## **Deadline 8 submission**

### **NACP submission on the provision for Non-motorised Users (NMU) along the A5025/A5**

Drawing Title
5025 OFF-LINE HIGHWAY IMPROVEMENTS
SECTION 5 - LLANFAETHLU
PROPOSED GENERAL ARRANGEMENT
PLAN - SHEET 1

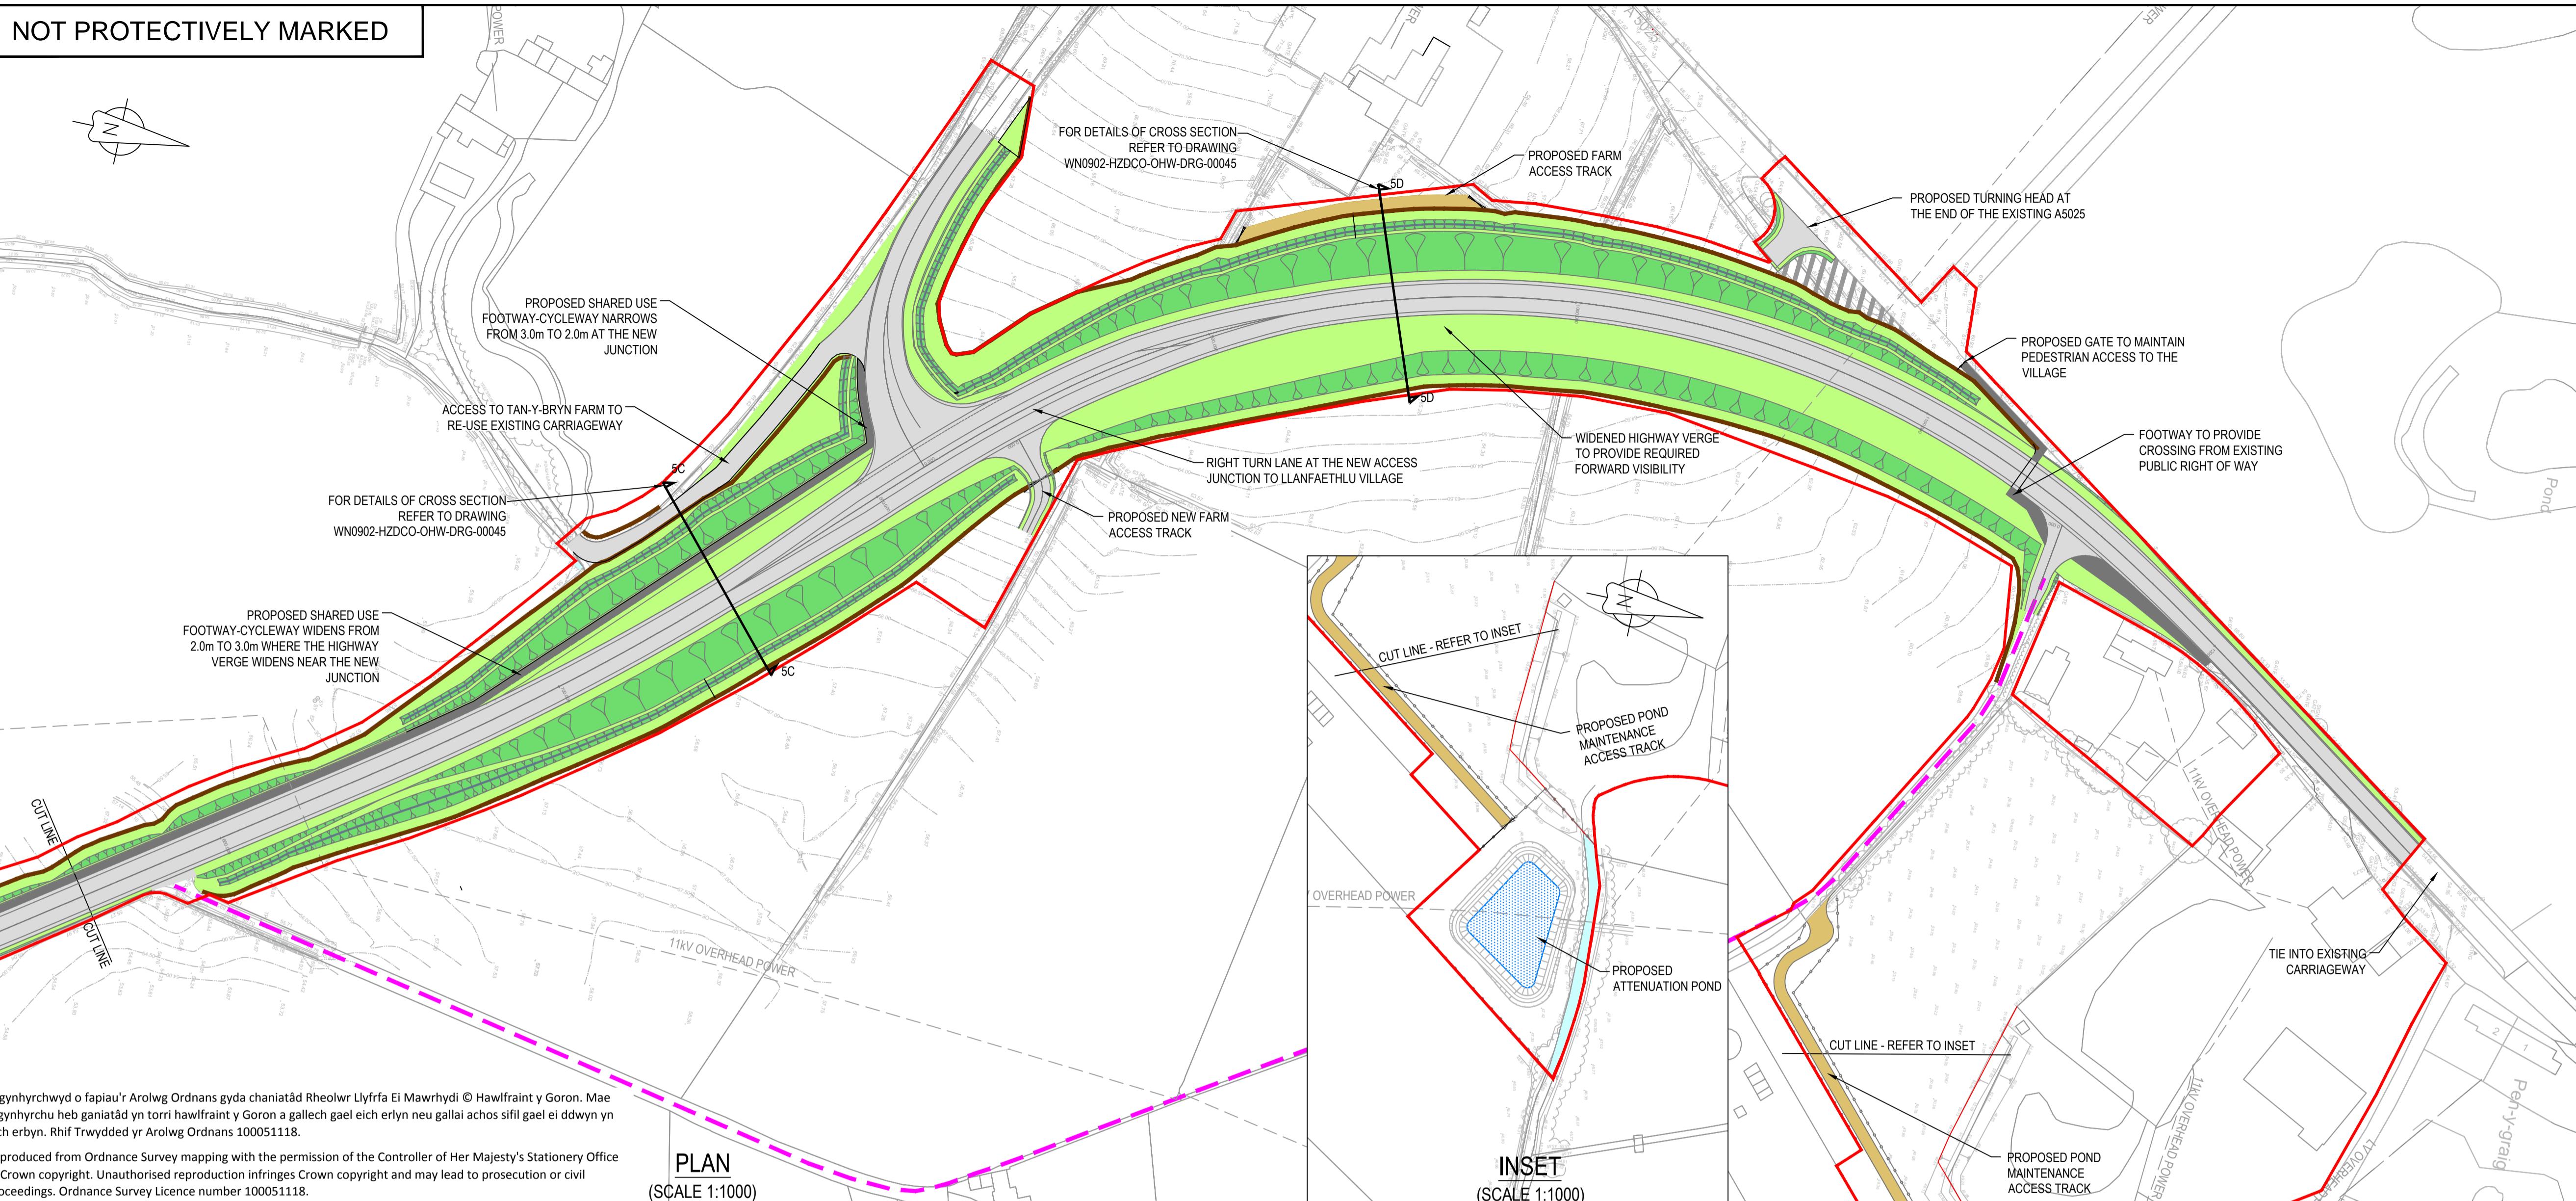
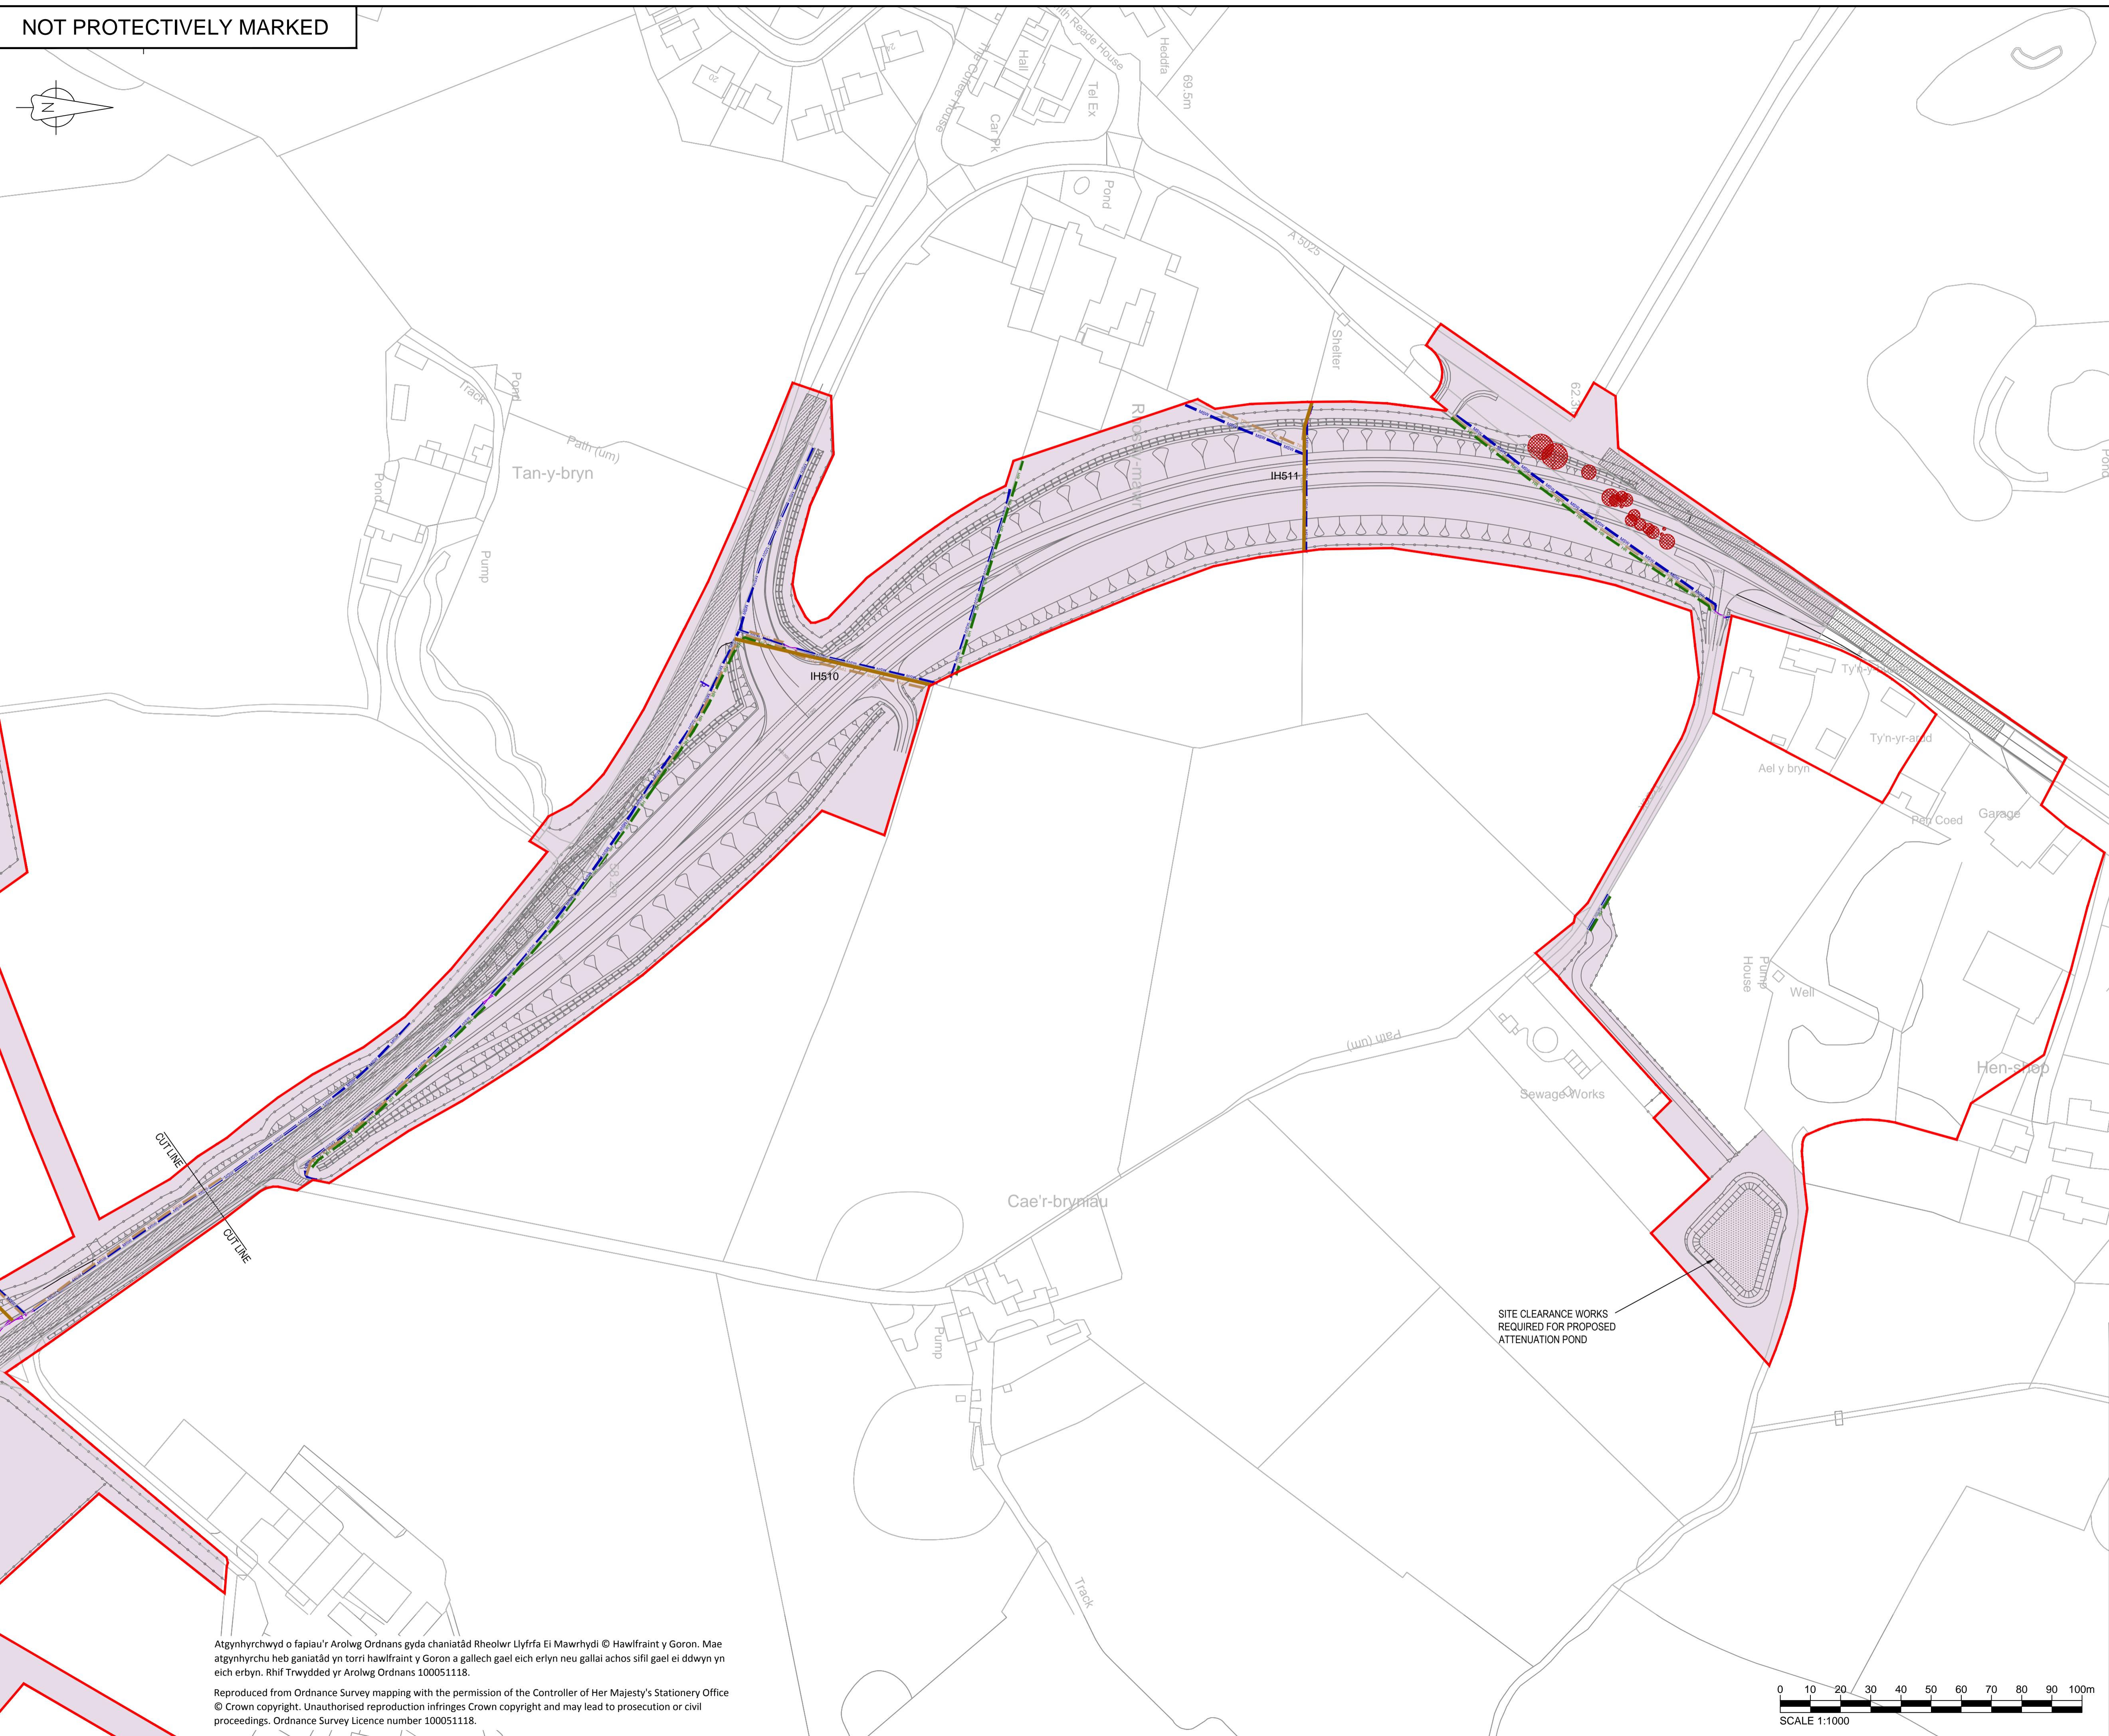
Unfortunately, the discussion at the meeting did not resolve the outstanding concerns about sections of the A5025 near Llanfaethlu, and Llanfachraeth where in the NACP's view mitigation for NMU is required. Also, there continues to be disagreement about the adequacy of the NMU mitigation proposed for the section of A5 between the A55 junction and the proposed new roundabout at Valley. To be clear, the NACP do not accept the justification presented by the applicant, during the discussion at the meeting, that no further mitigation for NMU is required. Therefore, the NACP will await the formal, considered, written responses at Deadline 8 from the applicant and IACC and reserve the right to respond more fully in writing at Deadline 9.
